MORGAN OFFSHORE WIND PROJECT: GENERATION ASSETS

Applicant's Response to IP submissions submitted at Deadline 2

Application Reference: EN010136

12 November 2024

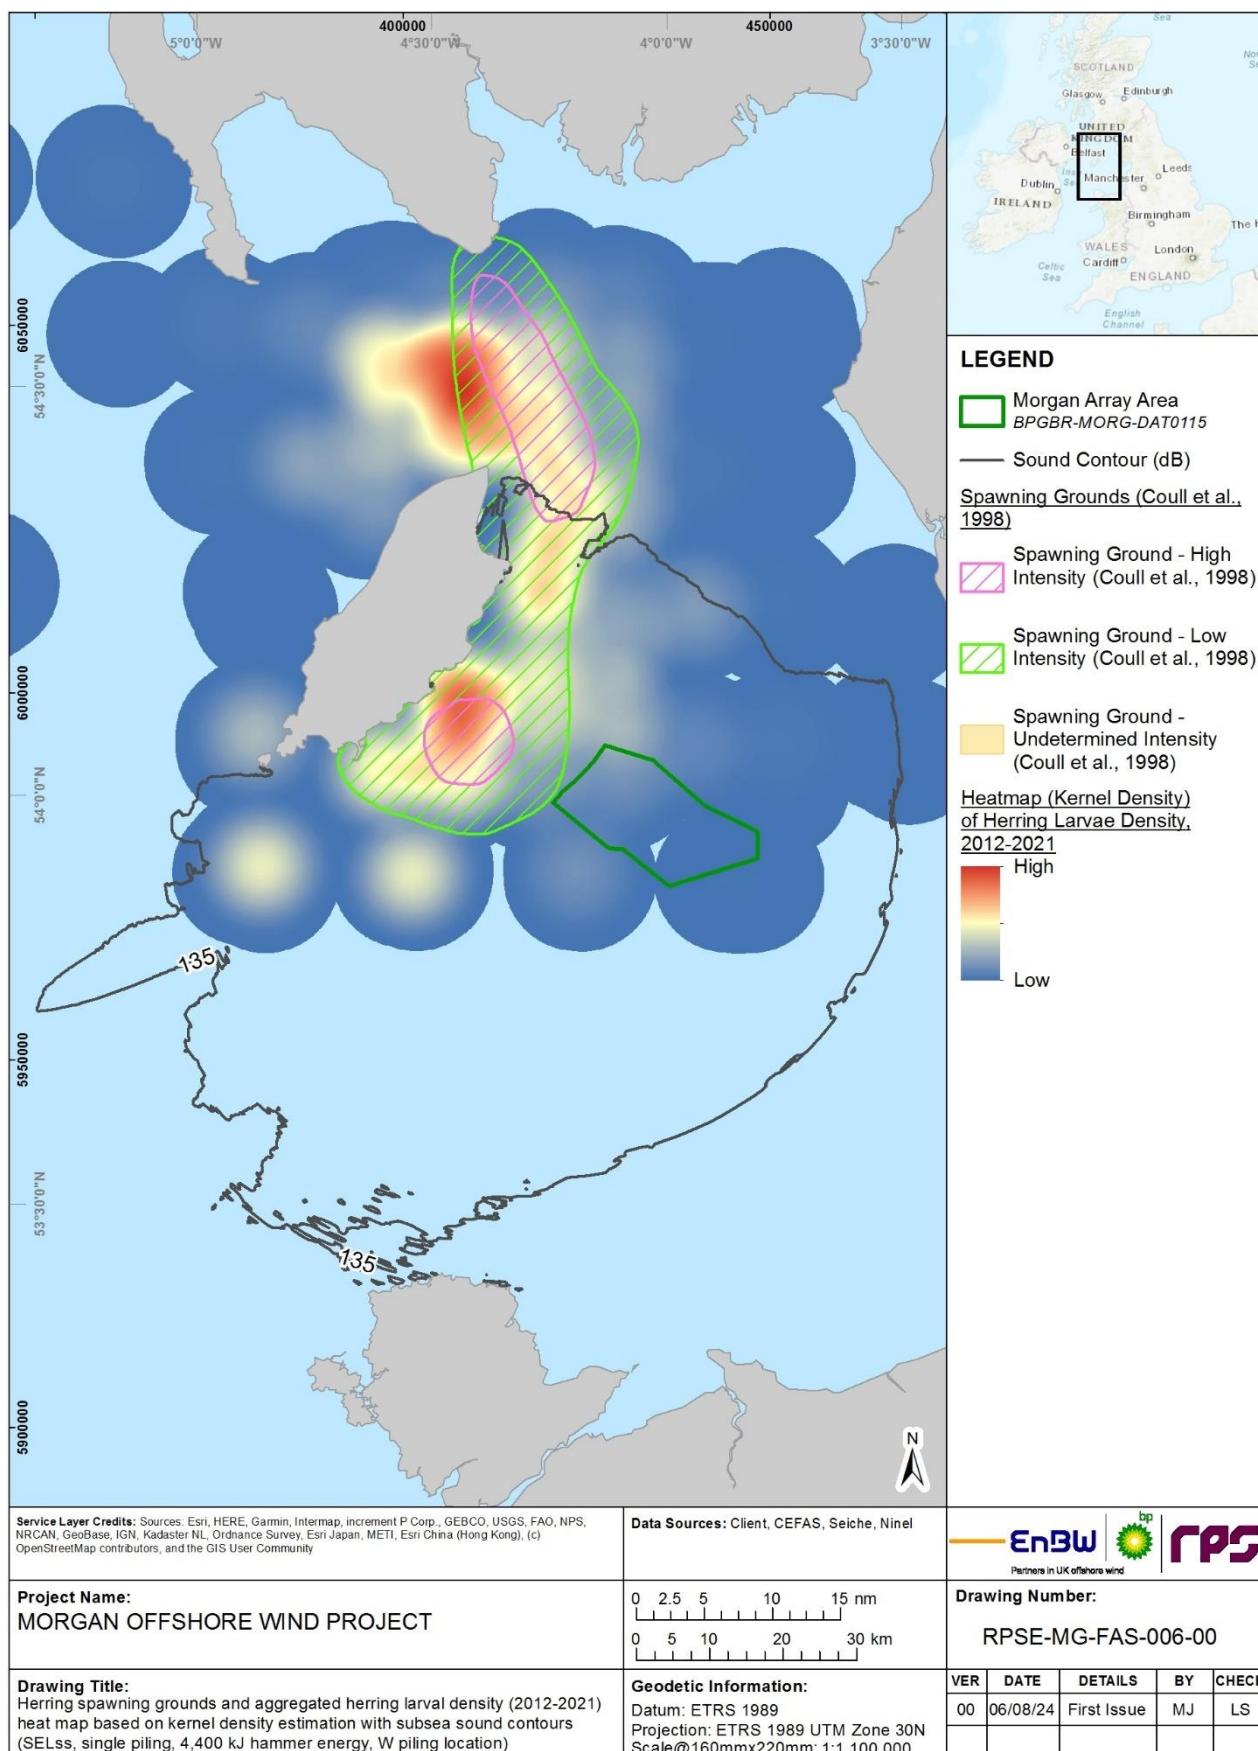
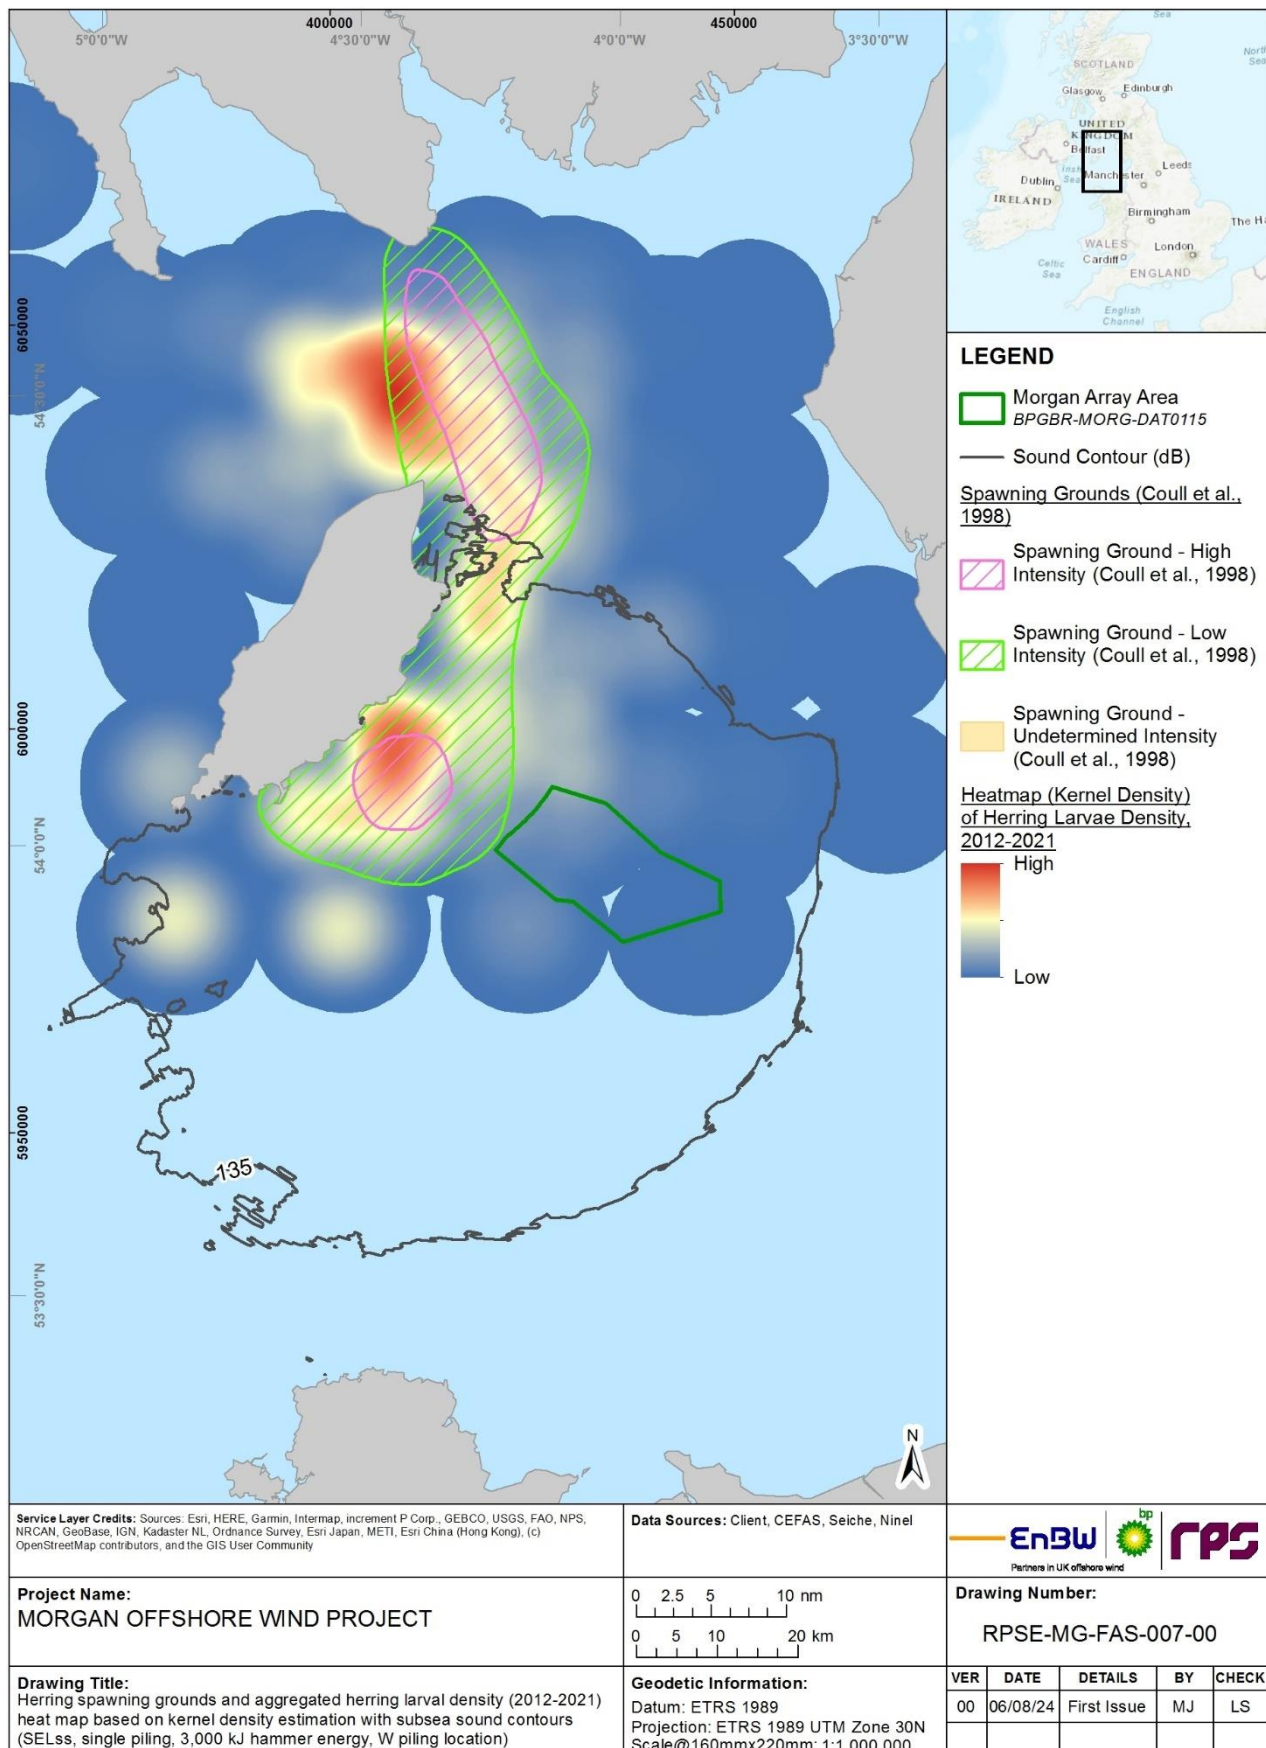
Reference	Written Submission at DL2	Applicant's response
	<p>spawning season (September to October, inclusive) which was recommended in MMO-RR-020 in order to protect spawning herring, and their eggs and larvae, from UWN disturbances during the spawning season.</p> <p>Both Figures 3.4 and 3.6 from the fish ecology chapter show that the UWN contours for the 135 dB behavioural response threshold as per Hawkins et al. (2014), <u>fully overlap with the high intensity herring spawning grounds in the southeast of the Isle of Man, and partially overlap with the high intensity herring spawning grounds in the north and northeast of the Isle of Man.</u></p> <p>Given that no tangible mitigation strategies (using noise abatement technologies or otherwise) for reducing the range of behavioural effects in herring at their spawning ground from UWN, appear to have been outlined in detail at this point in the process, the MMO considers that <u>it is not appropriate to remove the requested restriction.</u></p> <p>Given the availability of effective alternatives to unmitigated piling – i.e. noise abatement measures to reduce noise at source - unmitigated pile driving cannot be justified on the basis that there are no realistic alternatives. Noise abatement measures would reduce the range of potential impact from UWN on sensitive species and habitats, an issue which is especially pressing given the wider context of the current expansion of offshore wind developments in the Irish Sea.</p> <p>To ensure adequate preparations are made and potential delays avoided, The MMO states that it is in the Applicant's interest to plan for and to incorporate noise abatement measures at the earliest opportunity.</p> <p>The MMO is content for the UWSMS to be finalised post-consent, however, removing the recommended</p>	<p>once available. The Applicant believes the UWSMS is therefore the best approach to consider the range of mitigation options and appropriate mitigation required.</p> <p>The Applicant and the MMO are continuing to engage on the need for seasonal restrictions and management of the effects of piling noise during fish spawning periods through the UWSMS. The Applicant welcomes the MMO's support for the ongoing development of the UWSMS, and the Applicant has provided further clarifications on underwater sound overlaps with cod and herring spawning grounds (S_D3_3.1 Annex to the Applicant's response to Written Representations from the MMO F01) to further address this.</p>
